<b>Title</b>	Noise response to ISH5 and documentation review		
<b>Project</b>	Gatwick Airport DCO		
<b>Reference</b>	28AD.NT.2.1	<b>Author(s)</b>	BHo
<b>Date</b>	22 March 2024	<b>Reviewer</b>	VC

1.1.1 This note sets out Suono’s response on behalf of CAGNE following on from Issue Specific Hearing 5 – aviation noise (ISH5). Action Point 5 arising from ISH5 requires “*CAGNE to set out the detail of what it feels is missing from the noise assessment, as stated.*”; this note fulfils the requirement.

Diagram 7.4.1: Distribution of Additional Awakenings due the Project in 2032 Versus 2032 Baseline, Slow Transition Fleet

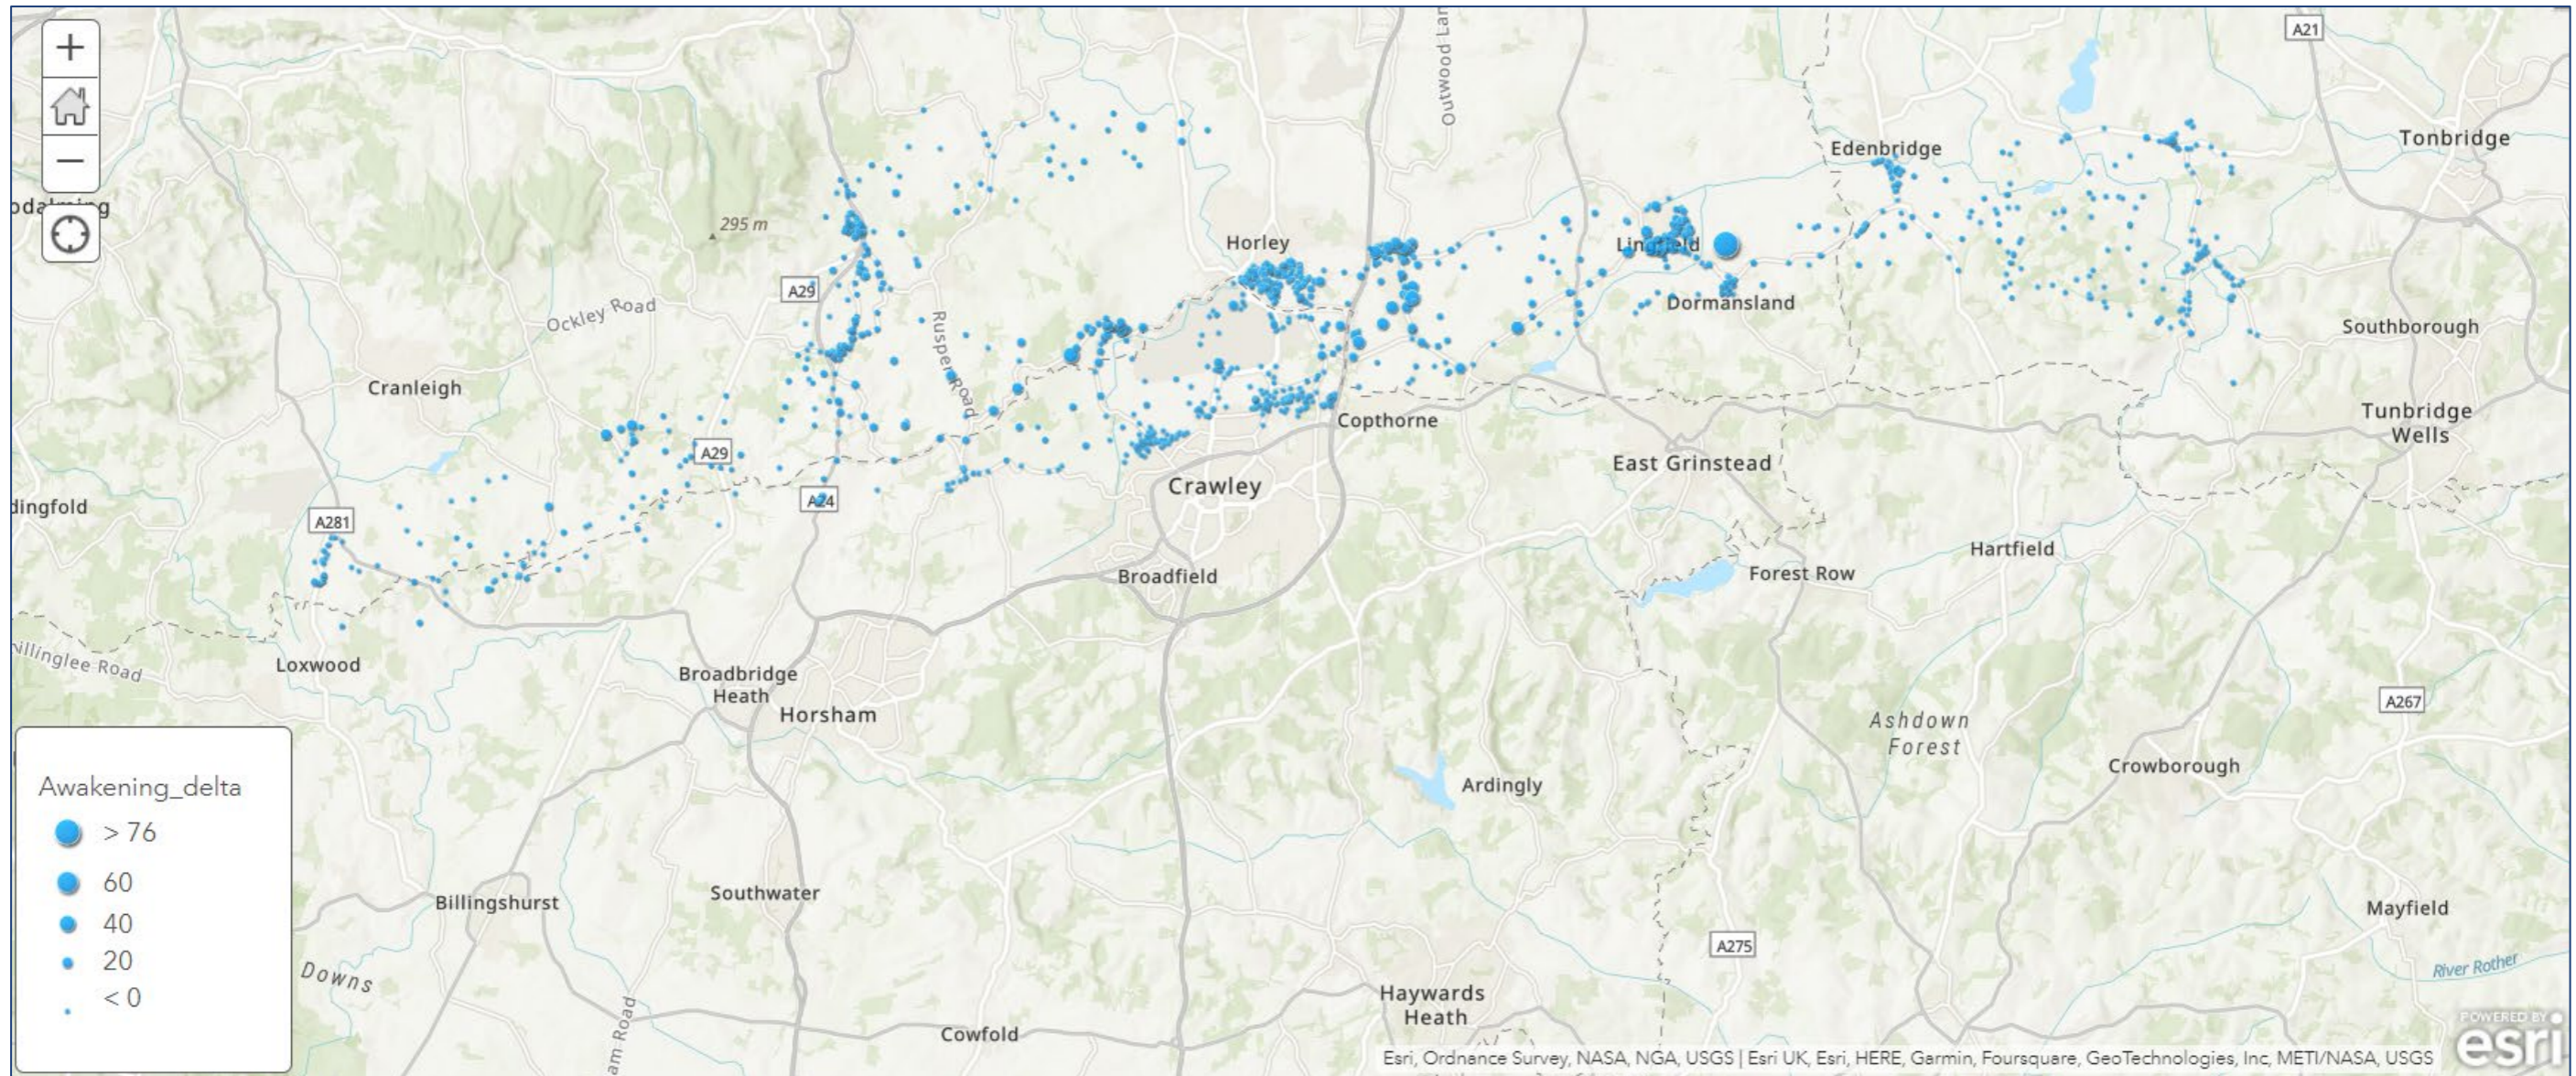
1.5.5 Appendix 14.9.2 Air Noise Modelling [APP-172] states at the end of section 7.4.7, “*it is currently unclear how many additional noise-induced awakenings are acceptable and without consequences for sleep recuperation and health*” and does not at any point propose a threshold or criteria.

1.5.7 GAL underestimate the likelihood of awakening through only assessing airborne aircraft, when noise levels from individual ground-borne events have also been calculated and presented in the ES. These must be included. The Applicant should update their awakening assessment to include both air and ground noise sources and compare this against a SOAEL of one additional awakening over the year.
